General	
GEN2.7	At D2 the Applicant submitted an update to the Rights of Way and Access Plan [REP2- 003]. This was updated to address comments made by NCC at D1. What are NCC's comments on the updated plan?	The Council supports the updated Rights of Way and Access Plan and has no further comments to make at the present time.
	Air Quality	
AQ2.2	Is NCC content that the Proposed Development will not significantly increase the levels of air pollution within the wider area by increasing the number of vehicles?	<p>Baseline levels from DEFRA background maps for thirty-five of the nearest receptors (ten in Part A and twenty-five in Part B) shows the existing background levels of the following atmospheric pollutants;</p> <p>Nitrogen Dioxide (NO₂) – 6 to 33 µg/m³, and; Particulates 10 and 2.5 micron (PM₁₀ / PM_{2.5}) – 8 to 24 µg/m³.</p> <p>The modelling of nitrogen dioxide (NO₂) impacts for thirty-five human receptors has shown that the difference between Do-Minimum (without dualling) and Do-Something (dualling of the two sections as proposed) results in an increase of 1.0 microgramme per cubic metre (µg/m³) or less for the opening year (2023) for the majority of receptors. Only one recept

Revision: P02

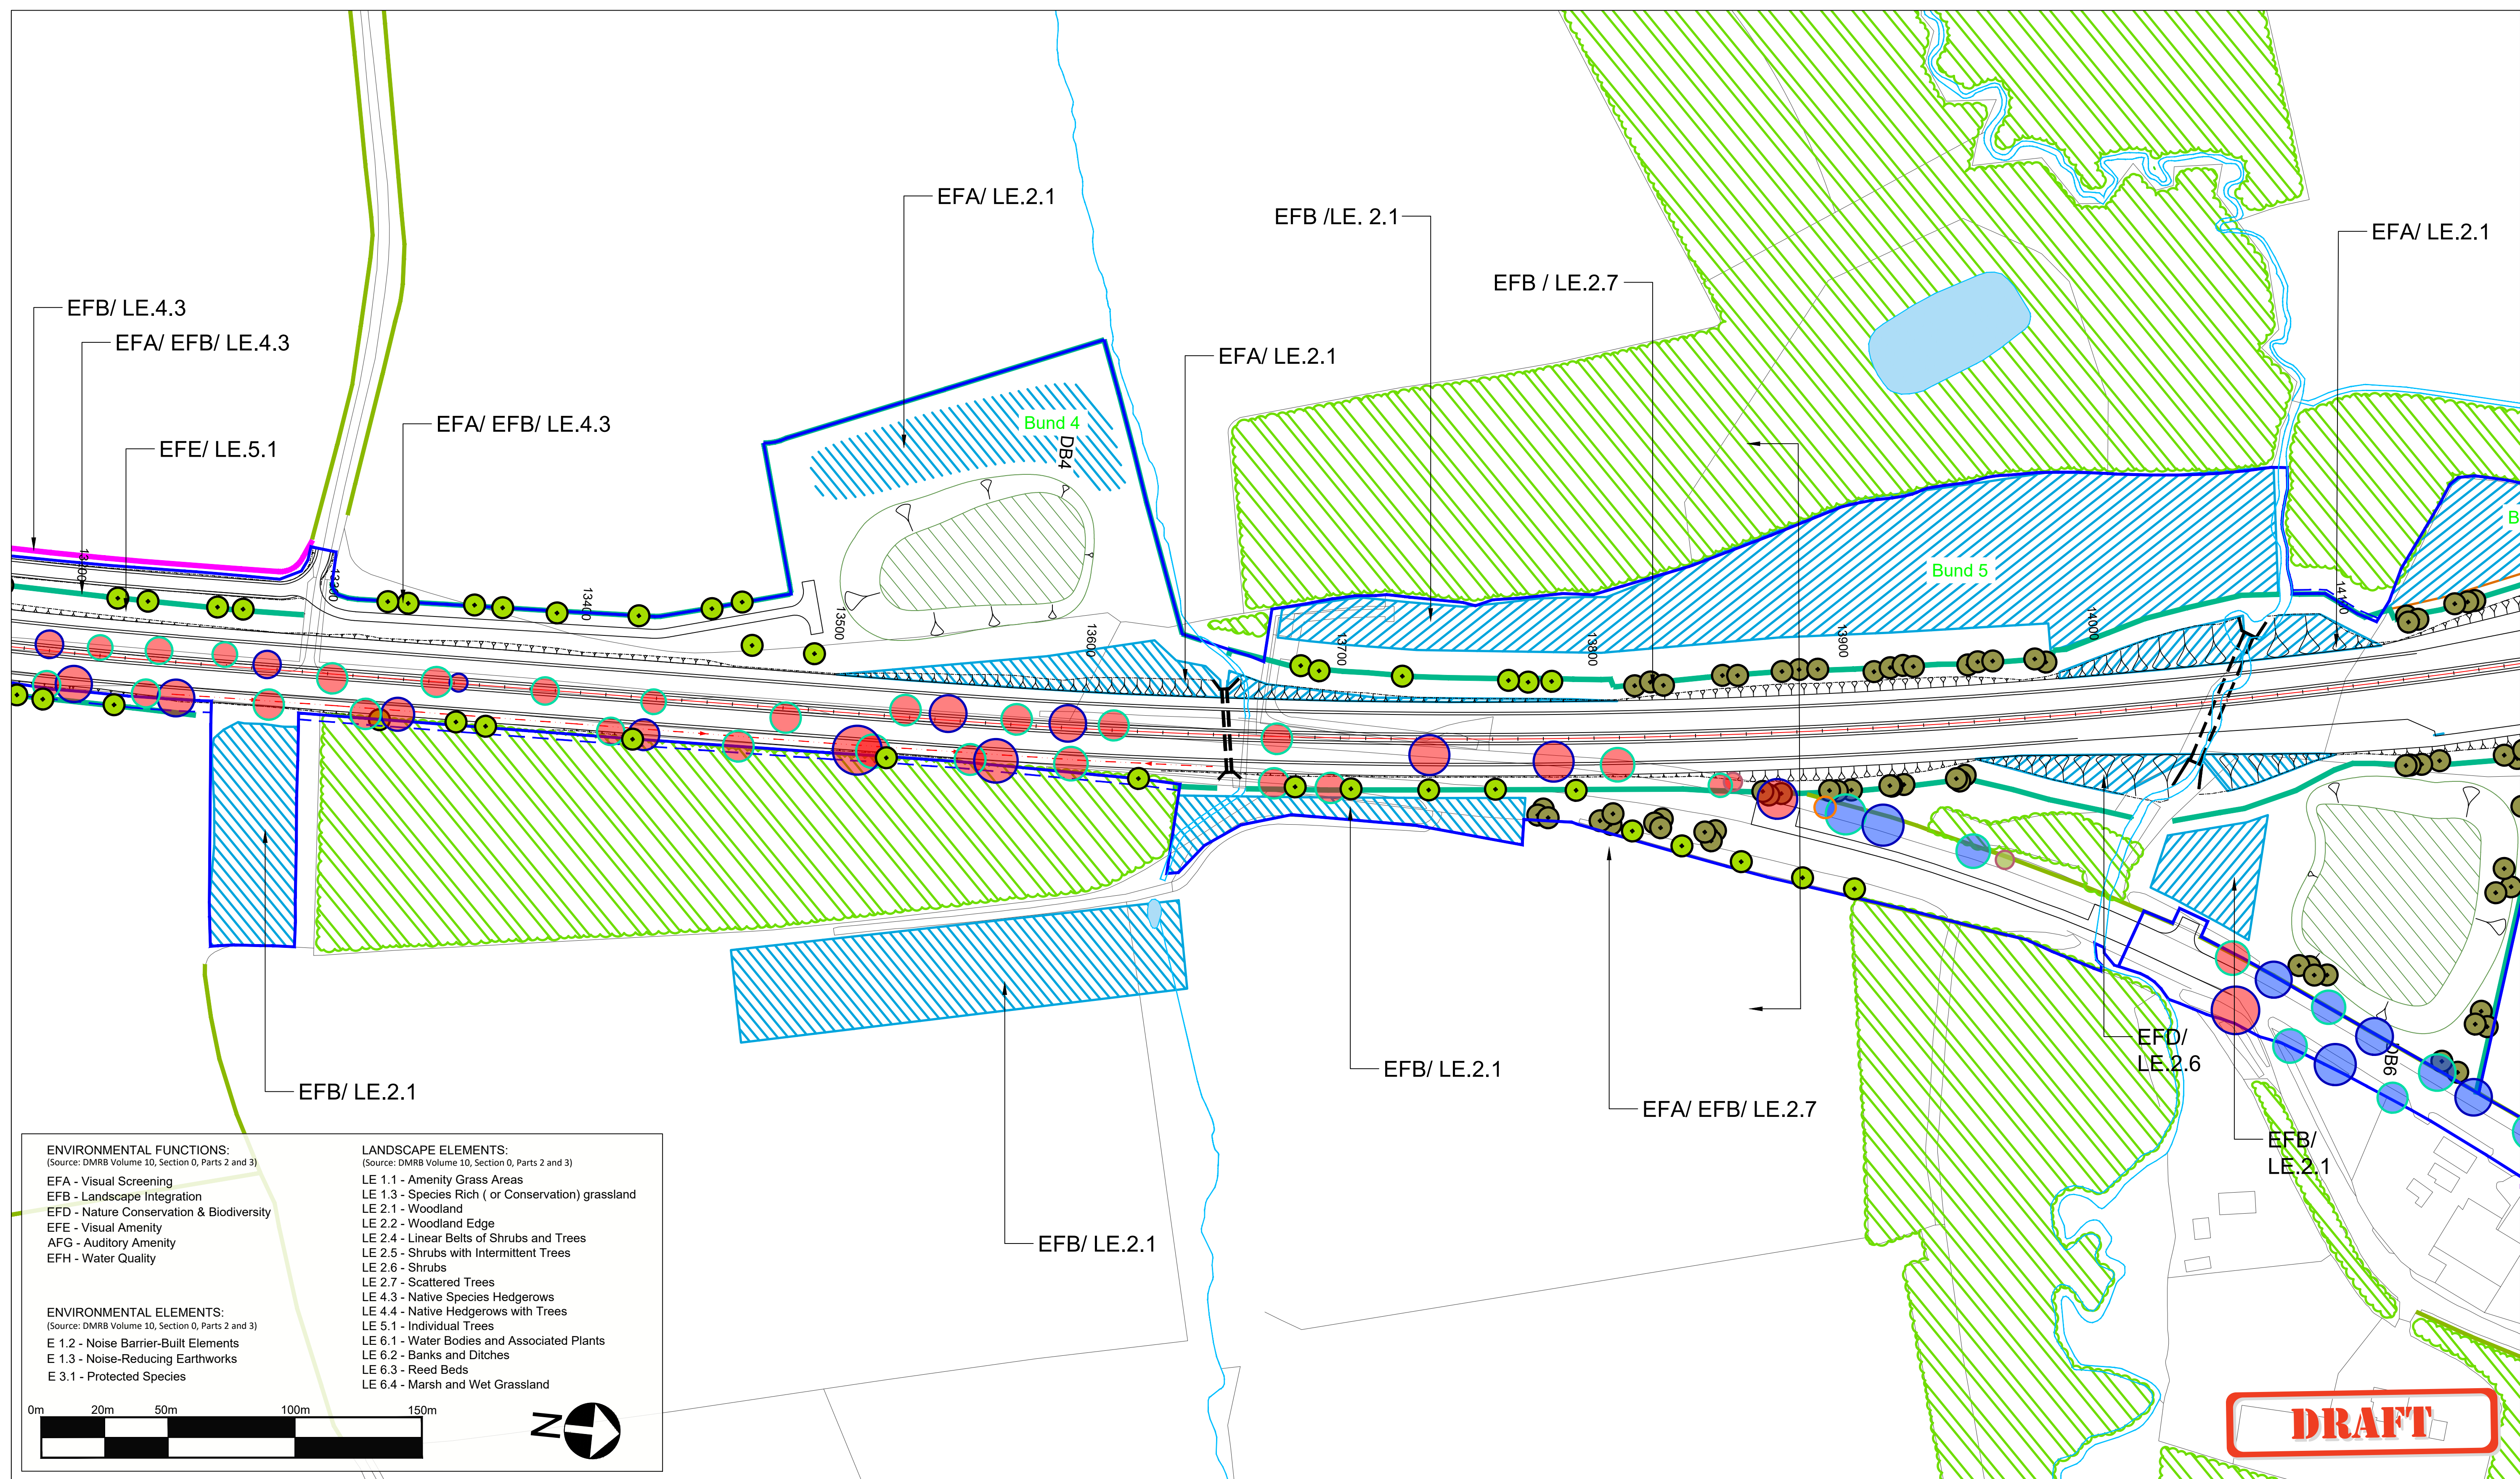
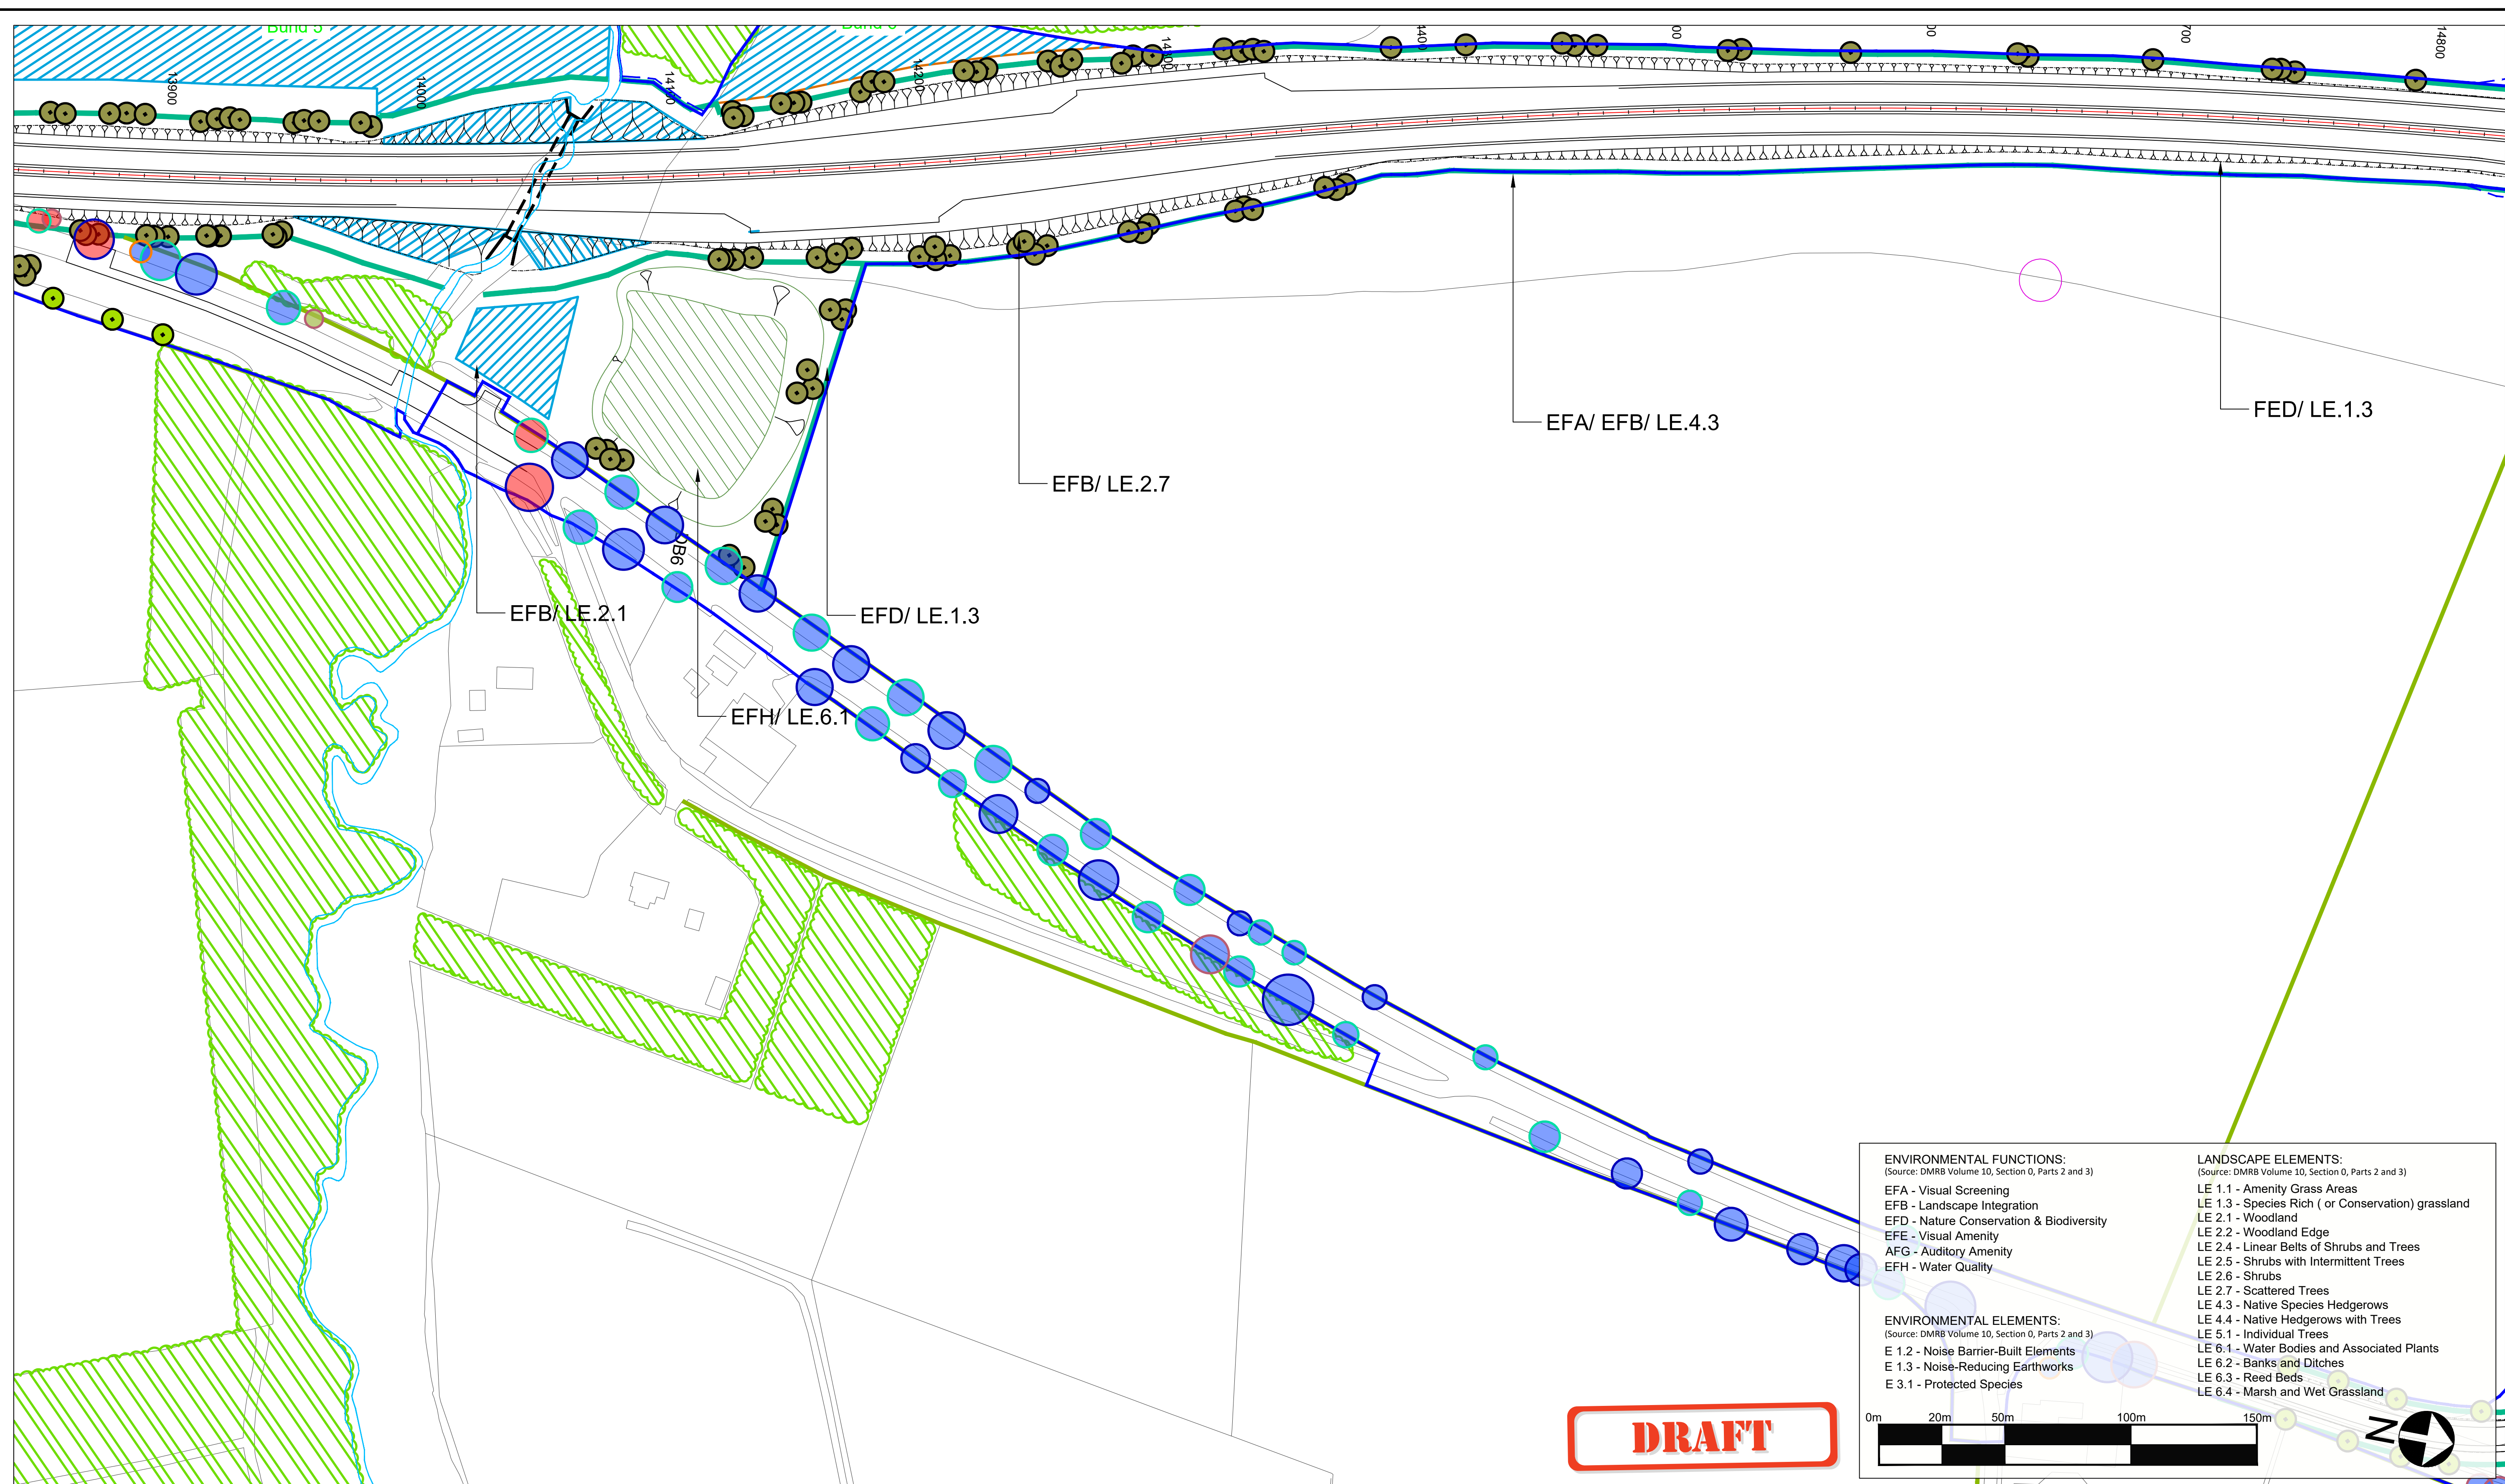
PART 2: no comments to make. The Council has reviewed the changes to Schedule 4 contained in the draft DCO – Revision 4 with respect to public rights of way and supports all of the changes.
	Landscape and Visual	
LV2.2	The plans which form Appendix LV.2 Trees to be Removed and Replaced at Coronation Avenue WQ LV.1.8 [REP1-044] are annotated 'Draft'. The Applicant is asked to explain how this relates to the requirement in R5(3) of the dDCO for the landscaping scheme to include a strategy for the replacement of trees which are to be removed at Coronation Avenue? IPs are asked to comment on the proposals for Coronation Avenue.	The number and location of replacement trees for Coronation Avenue as illustrated on the draft plans are appropriate. These proposals are now also reflected on 6.31 Landscape Mitigation Masterplan – Part A – Rev 2 submitted at Deadline 4.
LV2.6	Appendix LV3 Response to LV.1.13 [REP1-051] considers potential additional mitigation measures, their suitability and the prospect of potentially reducing significant effects to non-significant. What are the views of IPs in respect of these further potential mitigation measures?	Additional mitigation has been discussed and agreed with the Applicant at West Moor and Fenrother junctions and to the west of Causey Park Bridge. This is reflected on 6.31 Landscape Mitigation Masterplan – Part A – Rev 2 submitted at Deadline 4. This represents a welcome improvement in the landscape mitigation proposals although NCC agree with the assessment provided by the Applicant that the previously identified significant effects would remain.
